Our ref: DOC19/869044
Senders ref: SSD 8926

Subject: Response to Submissions – IMSA Gallipoli Campus, Auburn (SSD 8926)

EES has reviewed the Response To Submissions (RTS) prepared by Don Fox Planning dated October 2019 makes the following comments:

LA01

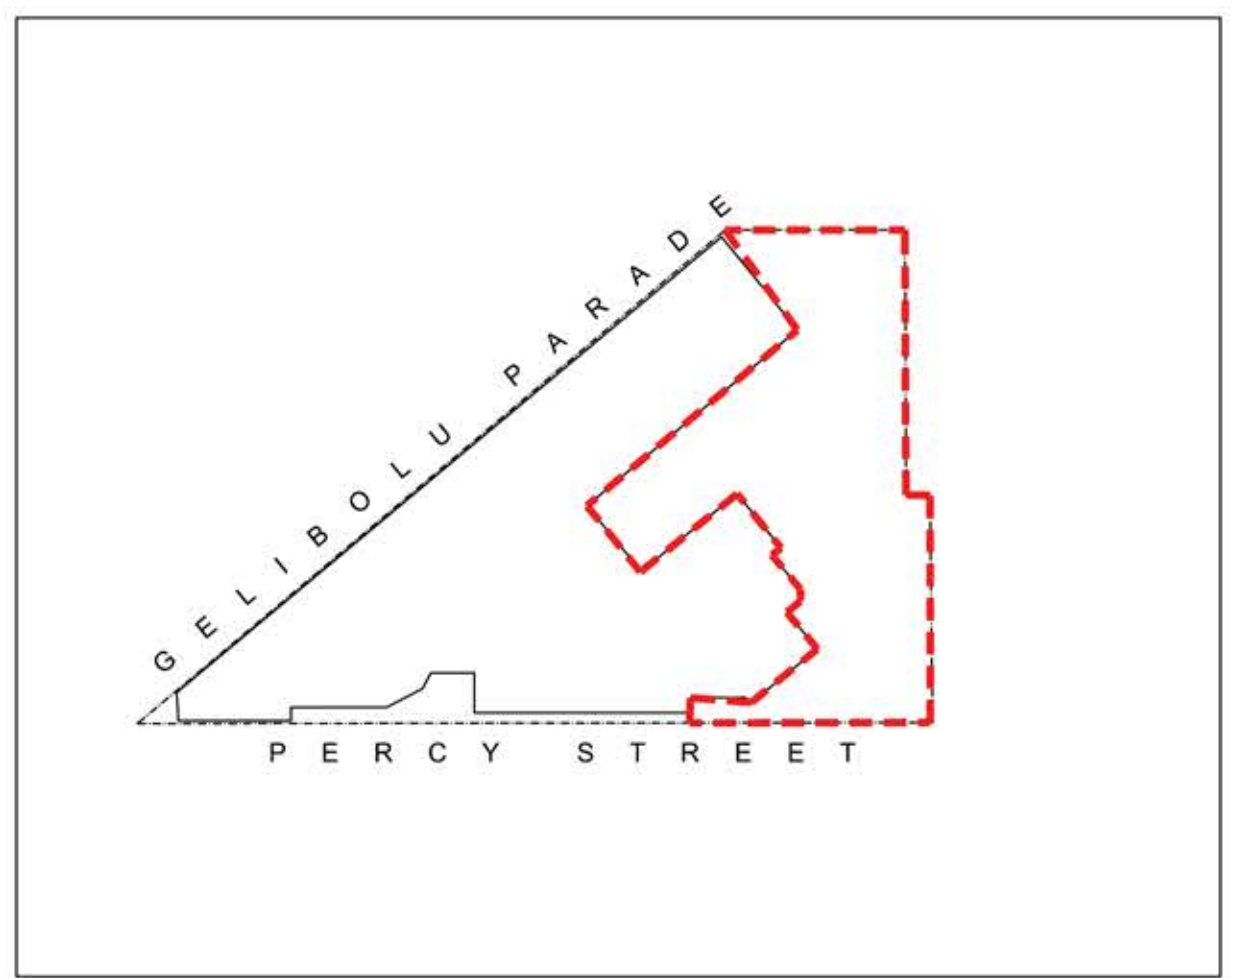
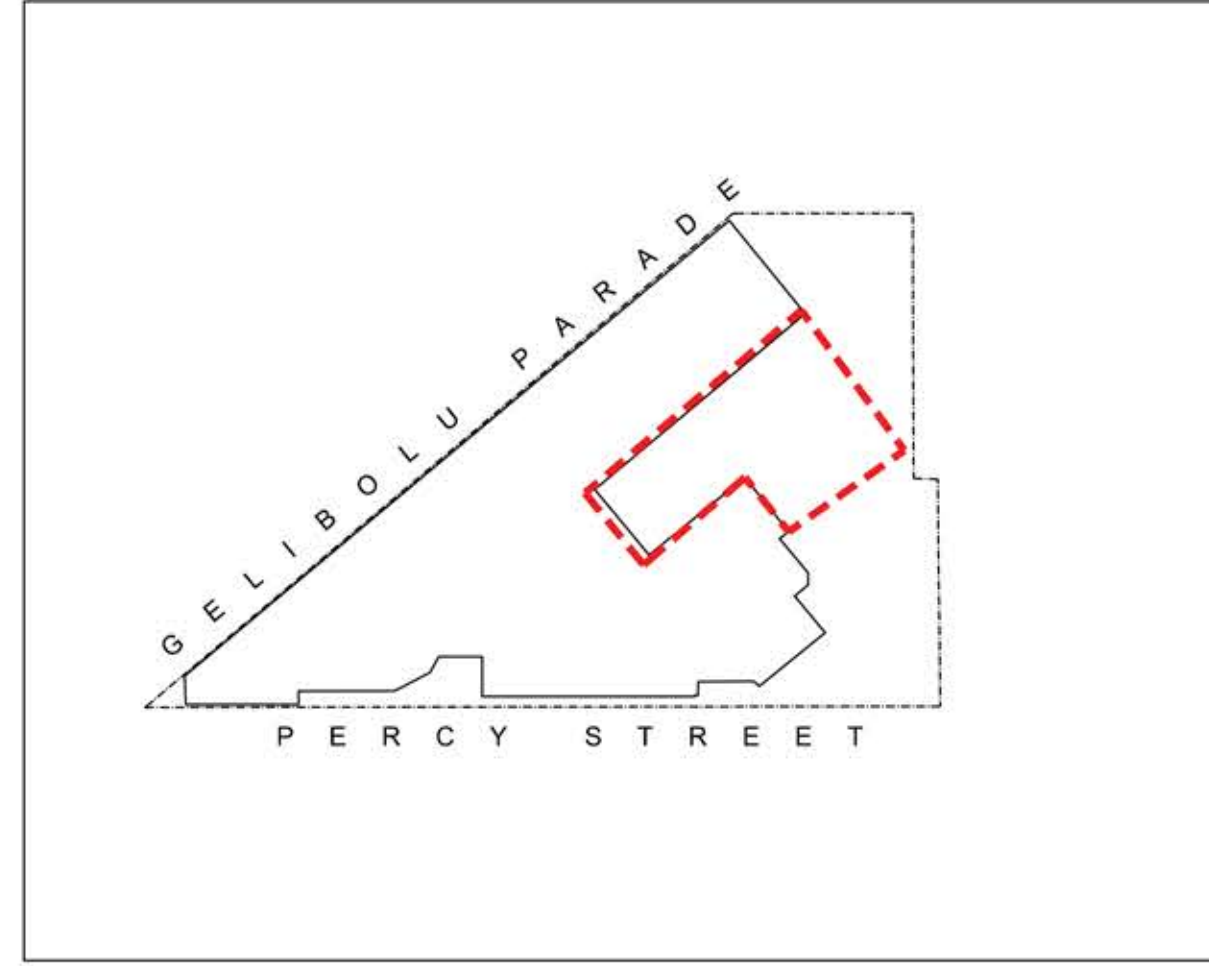
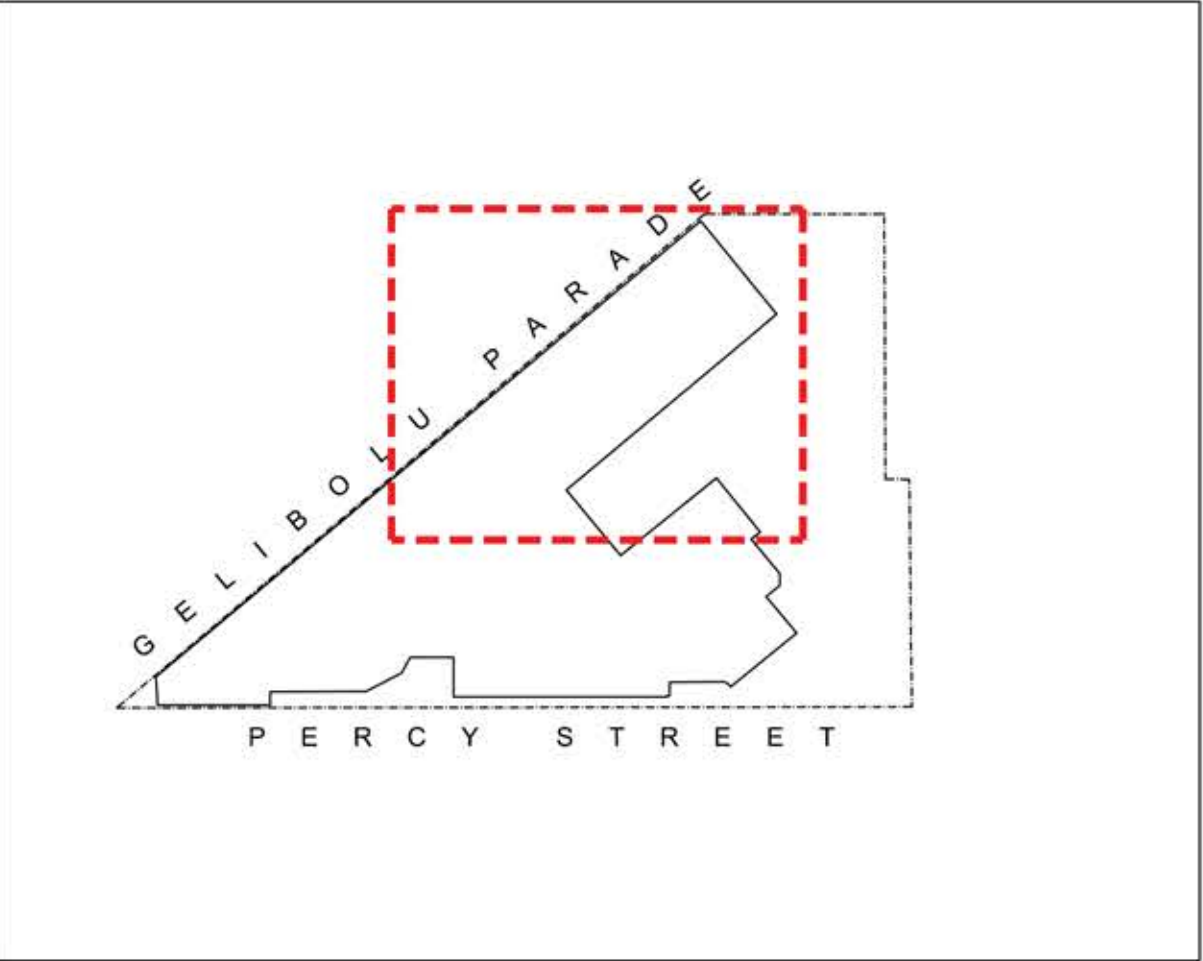
EES previous comments (dated 13 September 2018) haven't been adequately addressed. EES previously recommended that the *'site landscaping is amended to use a diversity of local provenance native trees, shrubs and groundcovers from the relevant local native vegetation community'*. The relevant local native vegetation community is most likely Cumberland Plain Woodland. The RTS says that the landscape plans have been amended to *'include more local native vegetation planting'*.

However, of the species listed in Figure 4 of the RTS, only one (Narrow-leaved Apple, *Angophora bakeri*) occurs in Cumberland Plain Woodland, albeit infrequently. EES would reiterate that the plant schedule should include species from the relevant local native vegetation community.

Please also note that Figure 4 (the plant schedule list in Appendix 2 Updated Landscape Package) is different to Figure 4 in the RTS report.
